2018/92802 - Midlothian garage

Condition 17 – Electric Vehicle charging points

An Electric Vehicle Facilities plan by Picea Design Ltd dated 23 Aug 2018 (Ref: PICEADESIGN LTD/704-SKL-08A-25-04-18) together with an email from Rebecca May of Seddon Homes and Rolec information for their Wallpod:EV Ready have been received

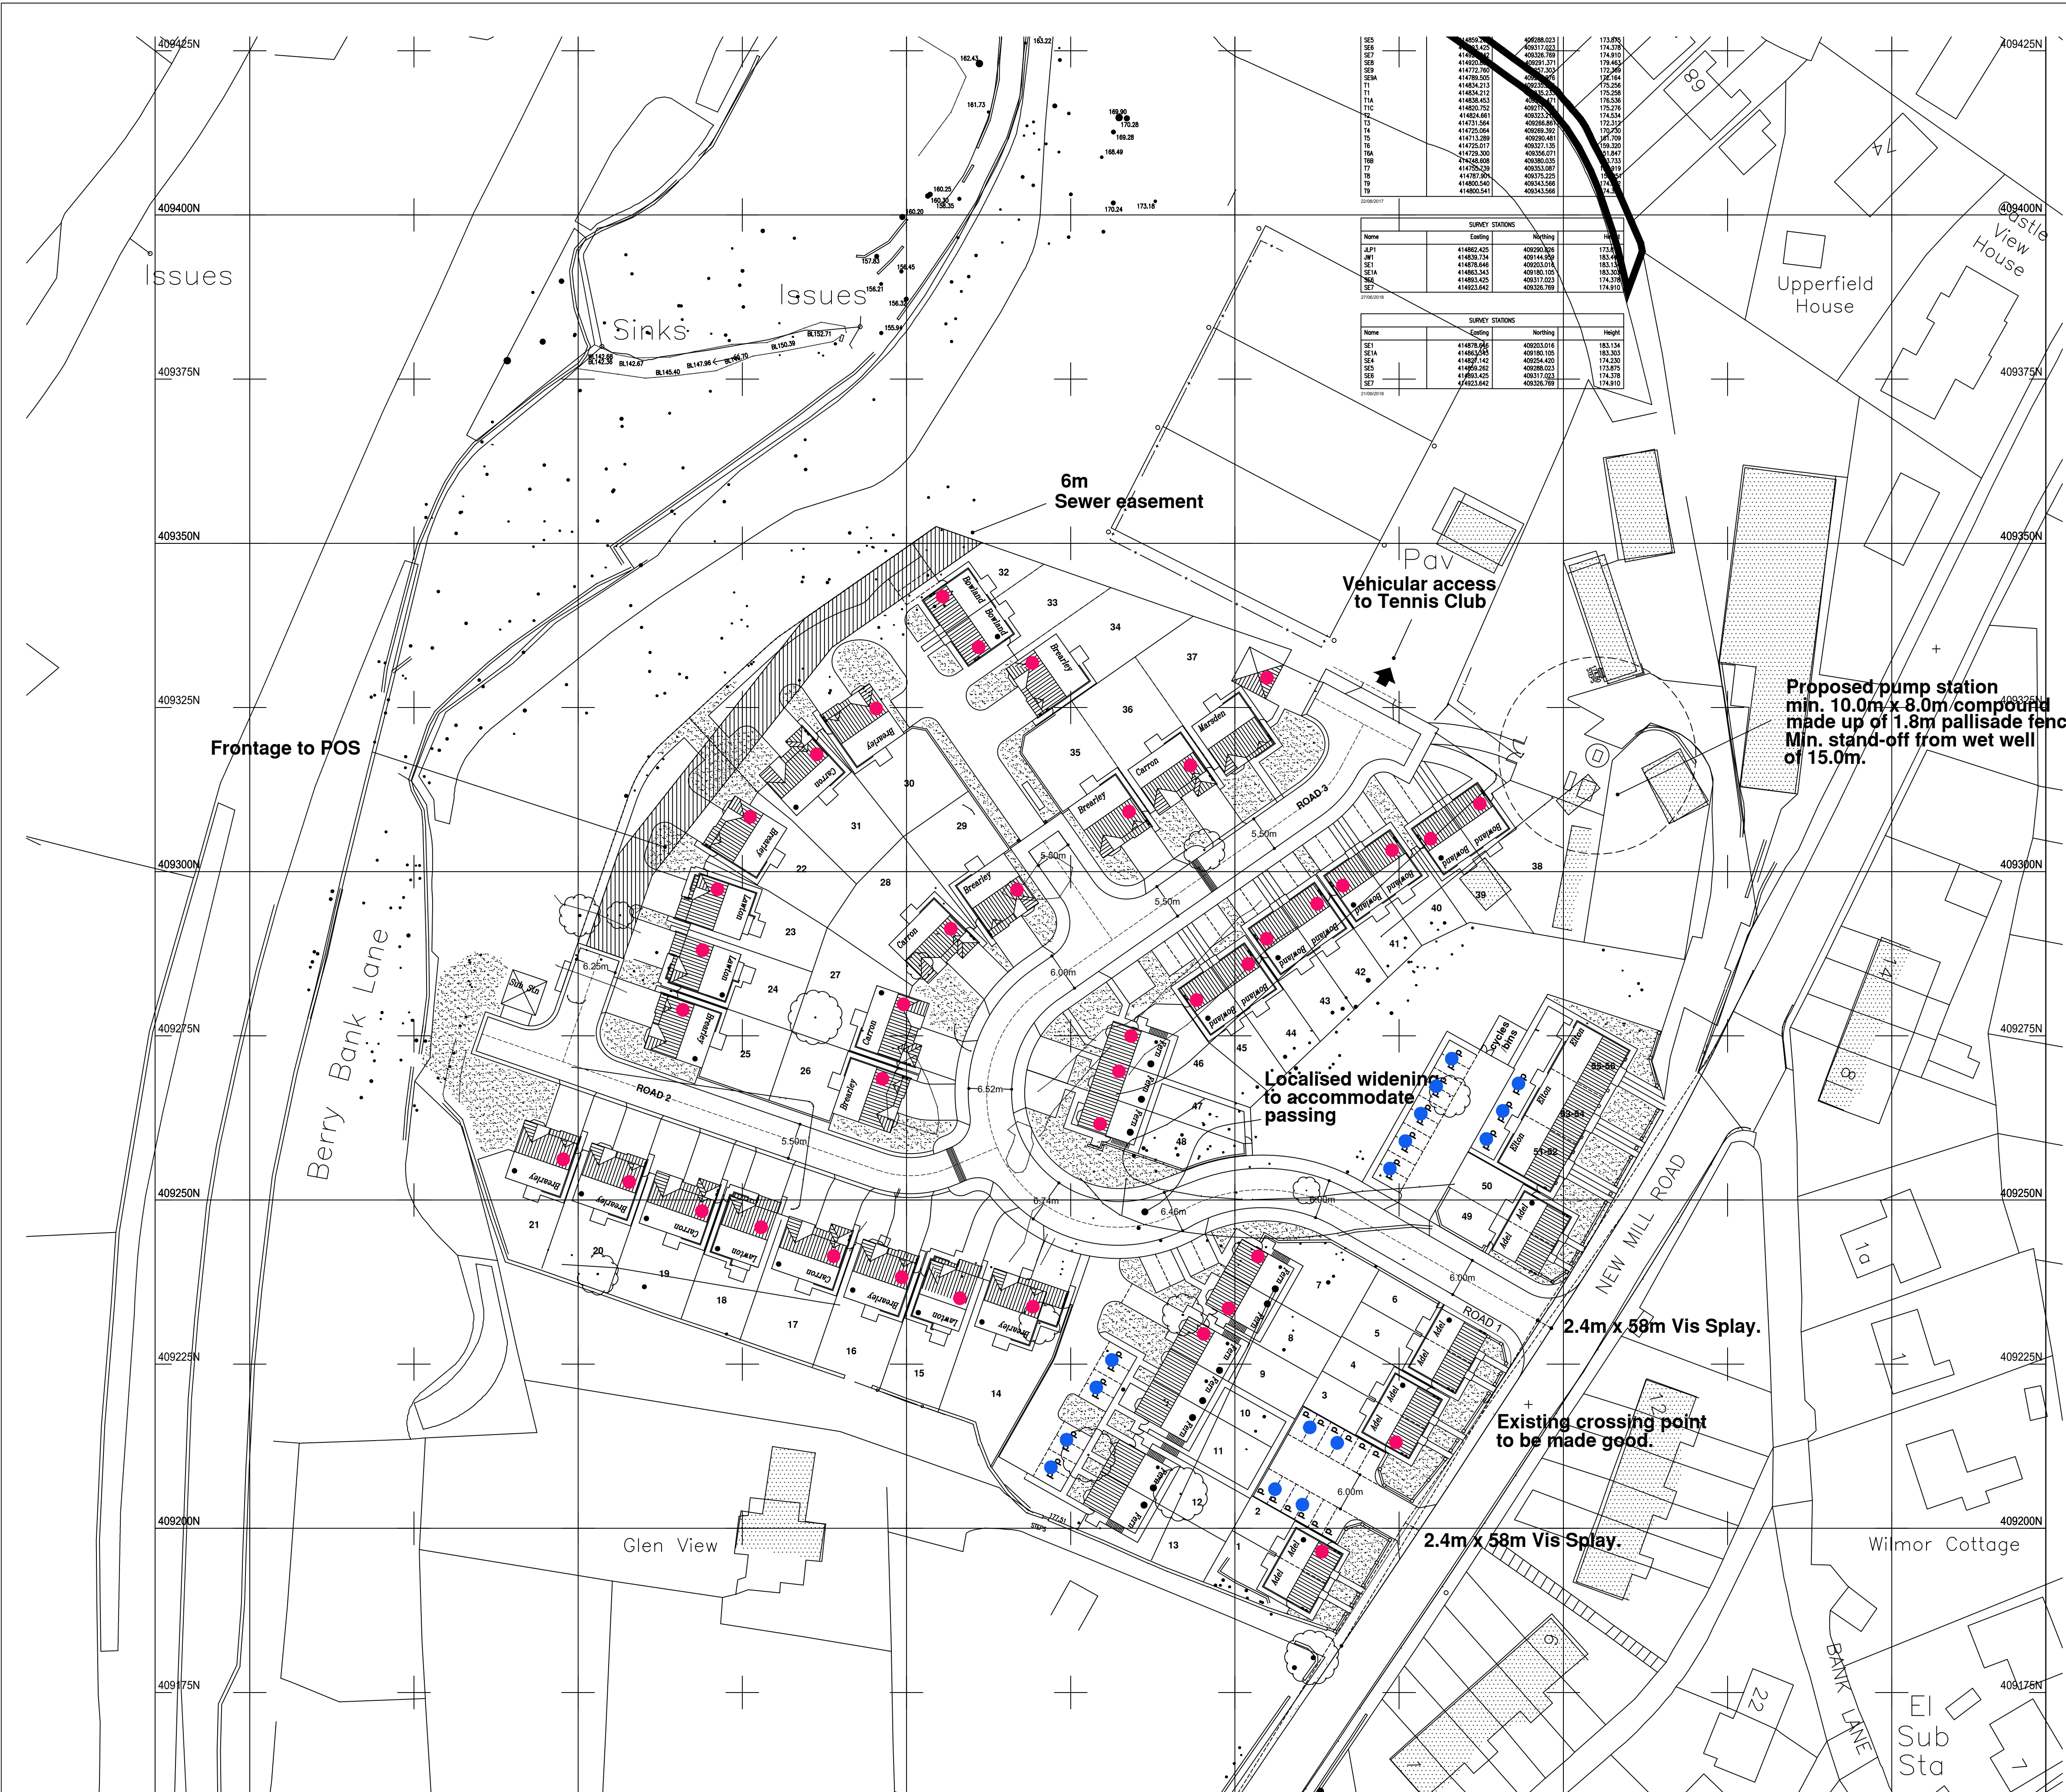
The information advises that an electric vehicle charging points will be provided to every property and that these will be supplied by a 16A fused spur. All of the plots with parking within the curtilage will have a Mode 3 charger and plots with detached parking will have a Mode 3 charger. The charger information provided shows the mode 2 charger which has a 13A socket outlet.

The provision of a charger to each property meets the scale of provision that we require. However, Mode 2 chargers are not considered to be acceptable, particularly when they have just a 13A socket outlet. This is insufficient to fully charge a typical electric vehicle within a reasonable time scale. Also details of the socket outlet for the proposed Mode 3 chargers is not provided.

The proposals are therefore insufficient to meet the requirements of condition 17. An acceptable standard would be a charging point for every plot that provides at least Mode 3 charging with a Type 2 socket outlet capable of providing a continuous supply of 16A and a maximum supply of 32A.
